12 May 2020

**RE: State Significant Development – Pick n Payless Metal Recovery and Recycling Facility
at 57-69 Tattersall Road, Kings Park (SSD-8375)**

Thank you for notifying Sydney Water of the abovementioned SSD, which proposes the operation of a metal recovery and recycling facility with a processing capacity of 130,000 tonnes of scrap metal per annum. Sydney Water has reviewed the application based on the information supplied and provides the following comments to assist in planning the servicing needs of the proposed development.

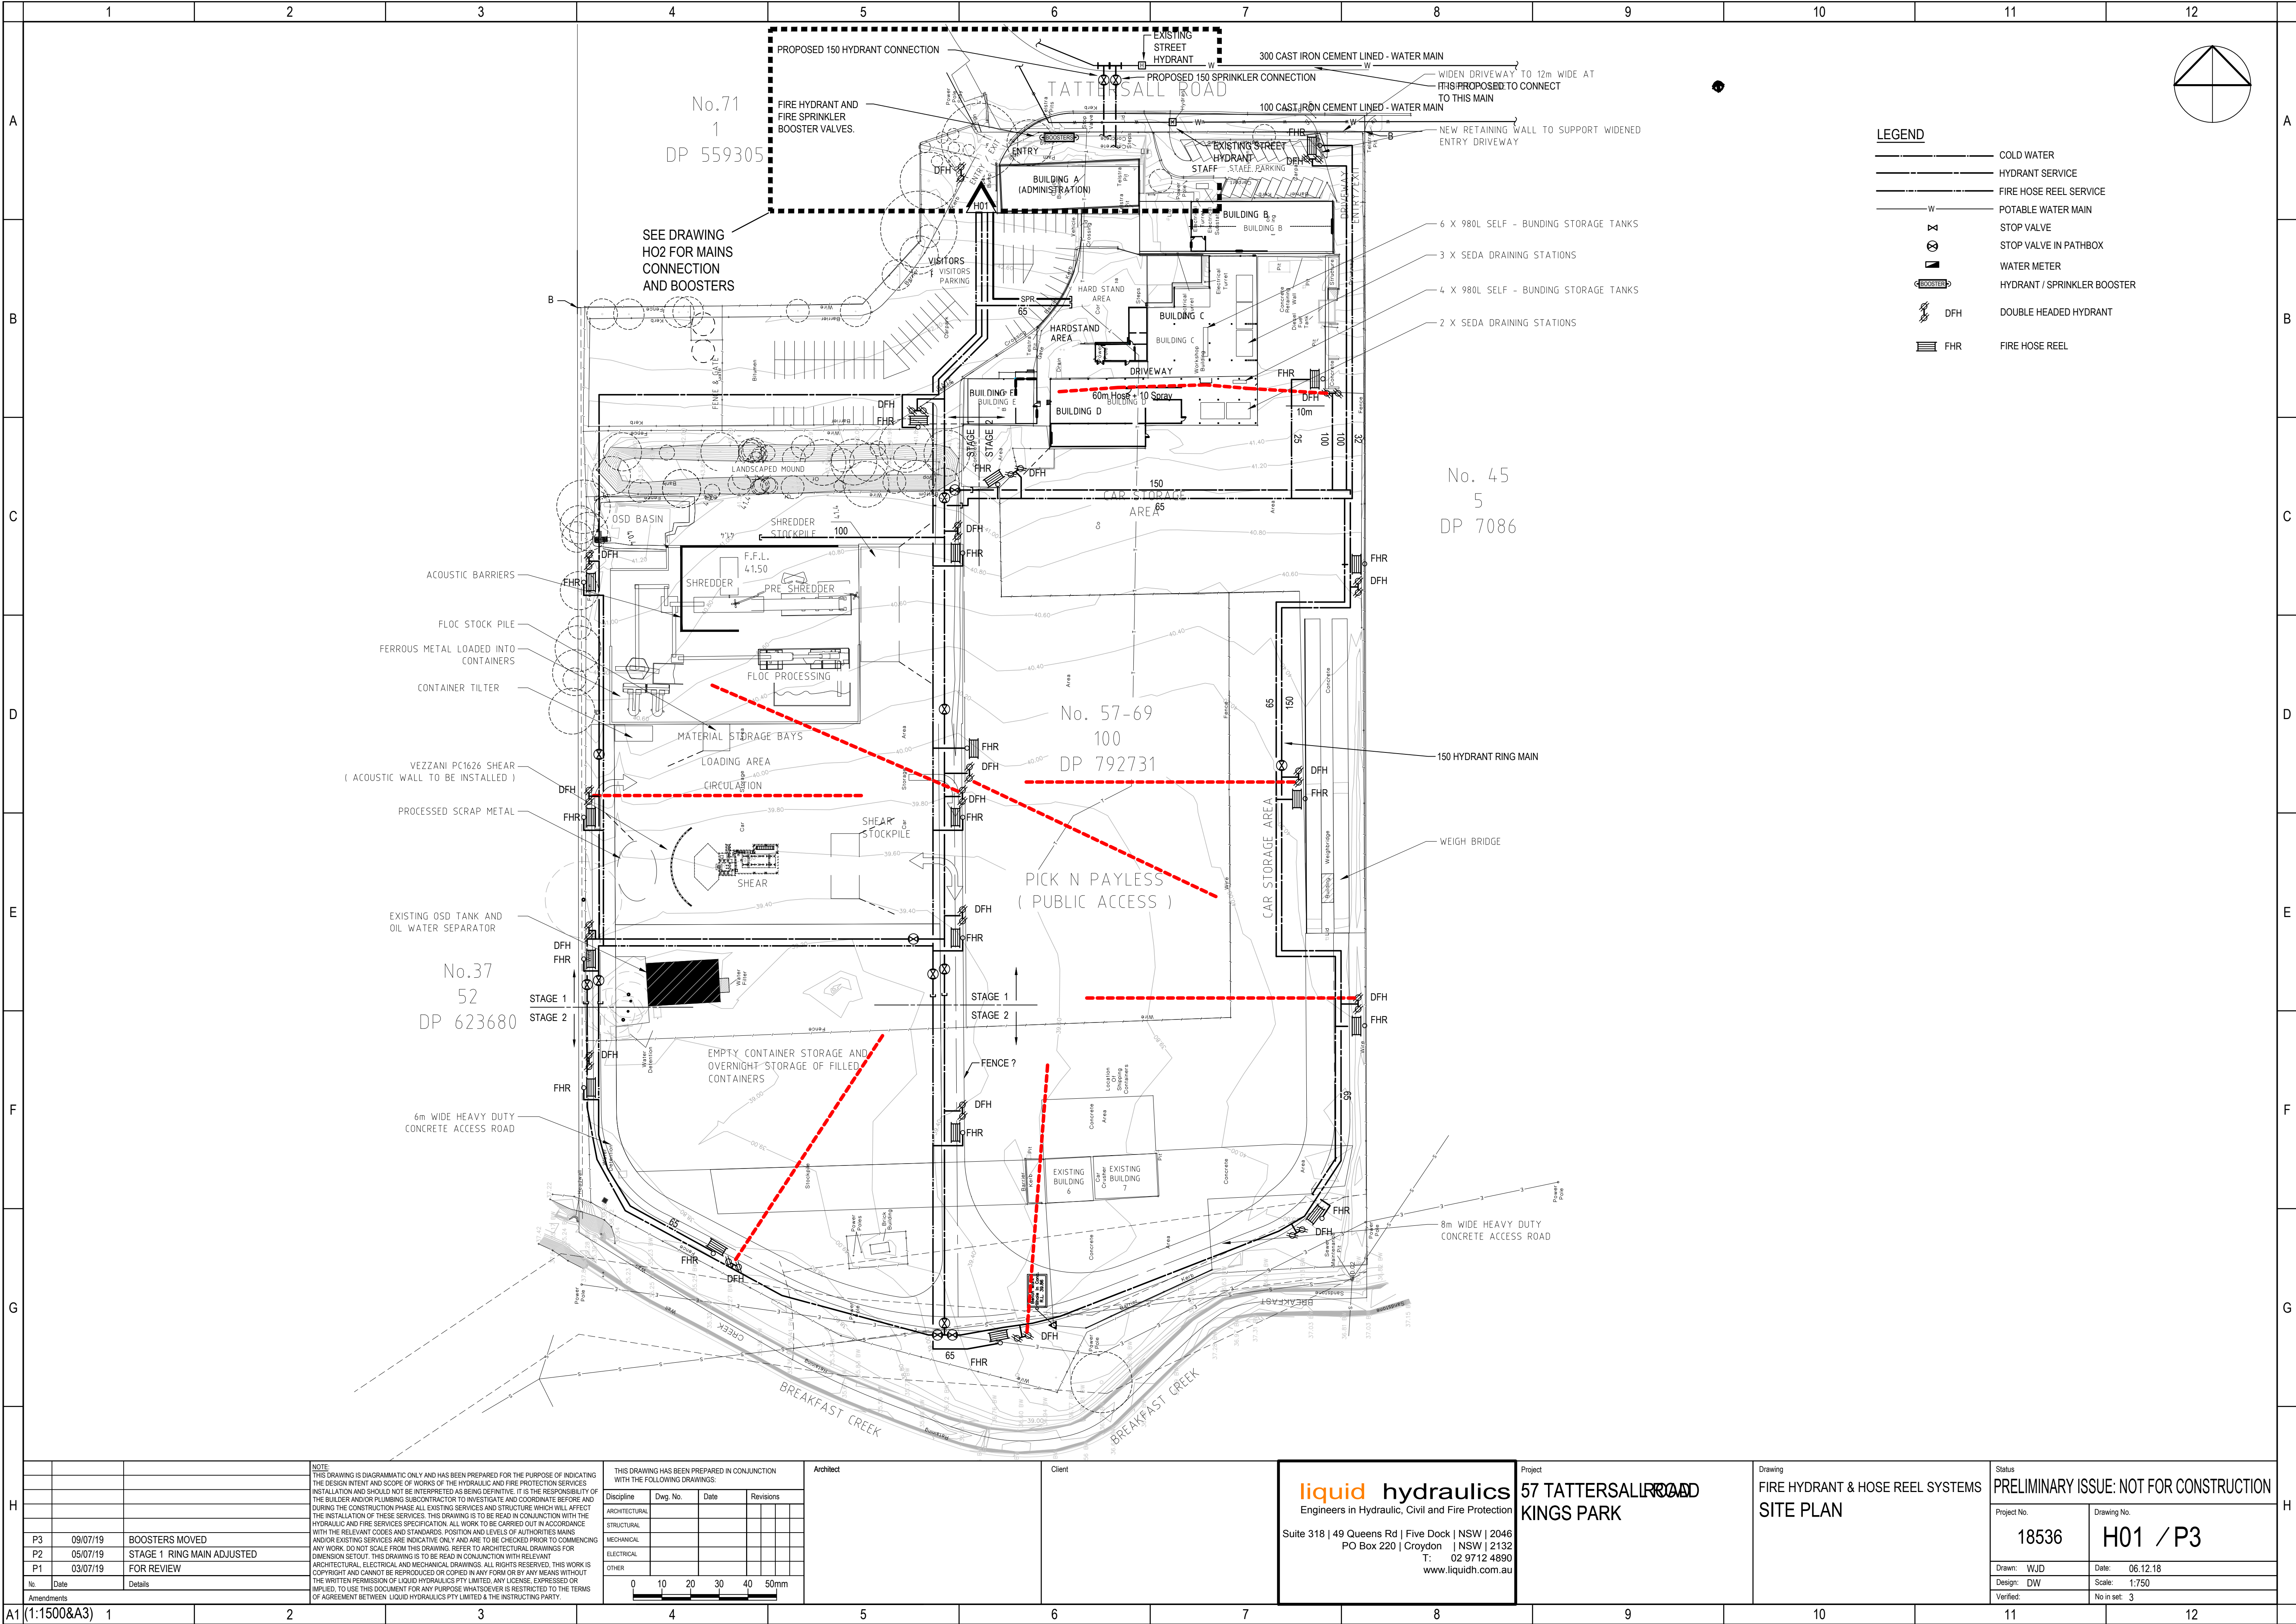
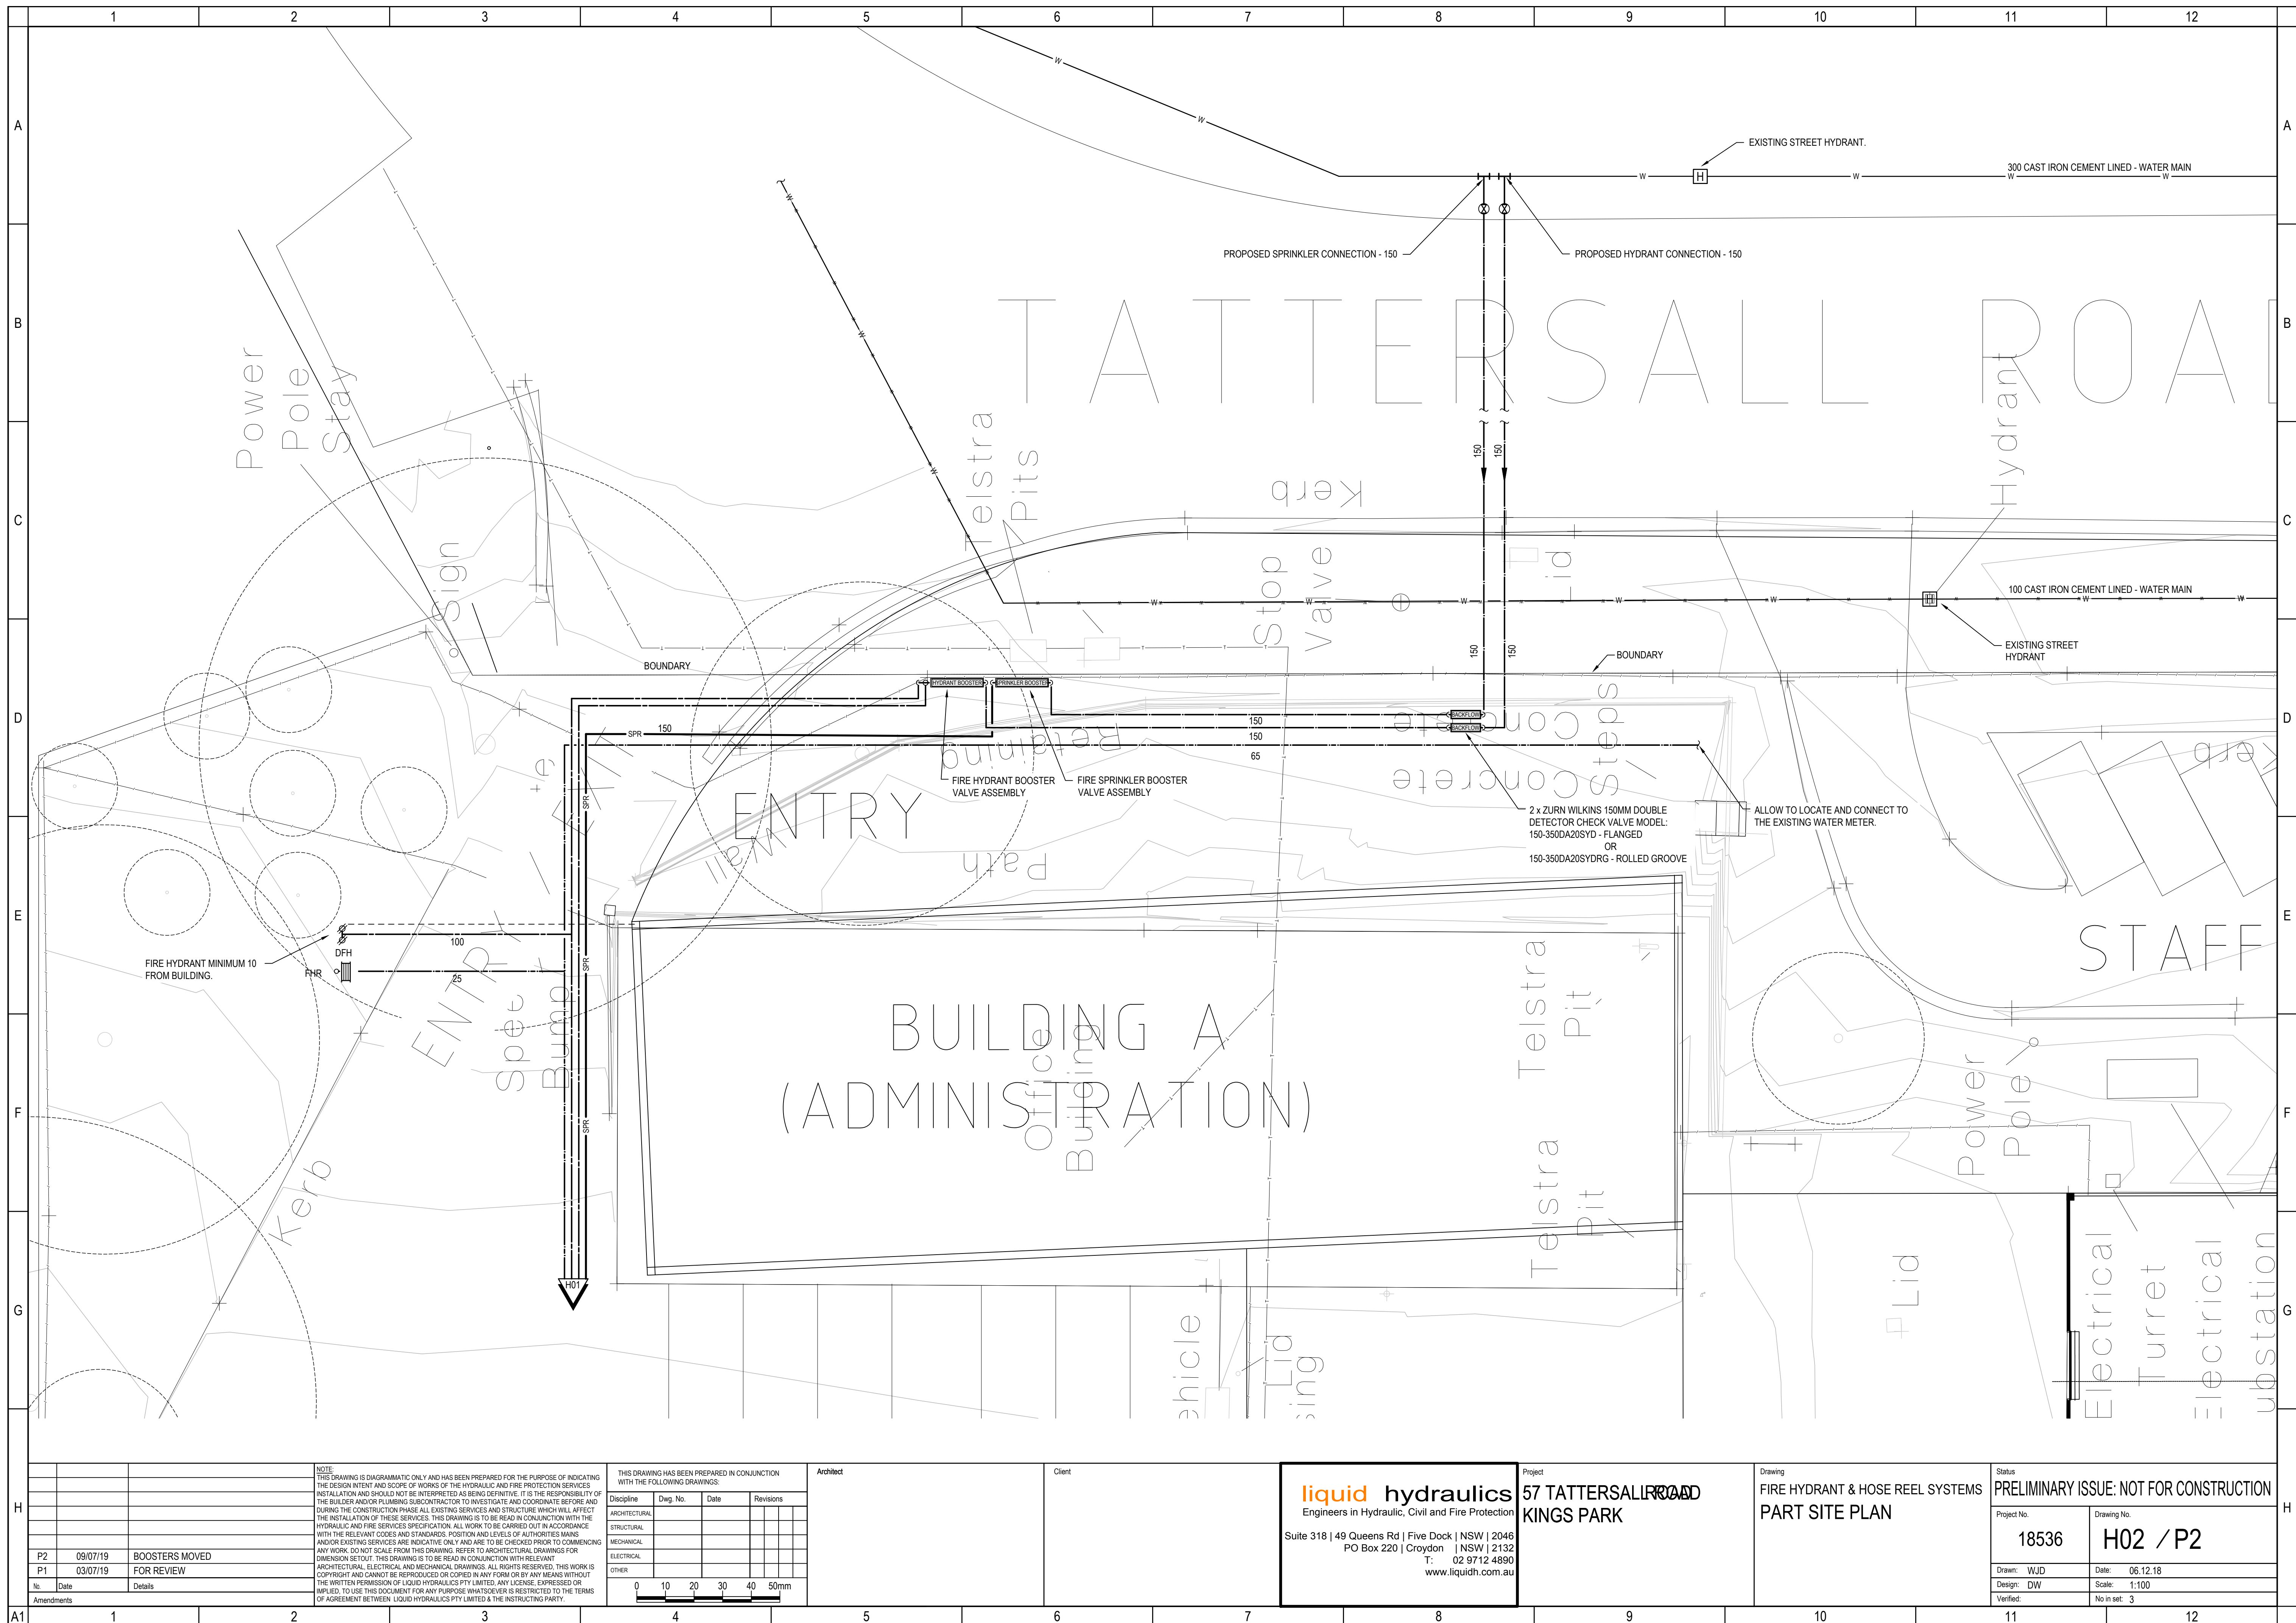
- The developer is proposing to connect to the DN300 watermain for firefighting. This is a trunk main and not available for connection. The developer will need to connect into the DN150/100 that also runs along Tattersall Rd. Note that the code specifies that the minimum pipe size for commercial / industrial developments should be a DN150. Depending on the potable water demand for the development, upsizing may be required. Also note, that it is the developer's responsibility to ensure that the actual performance of their firefighting system, drawing off the reticulation main, satisfies the relevant firefighting requirements.
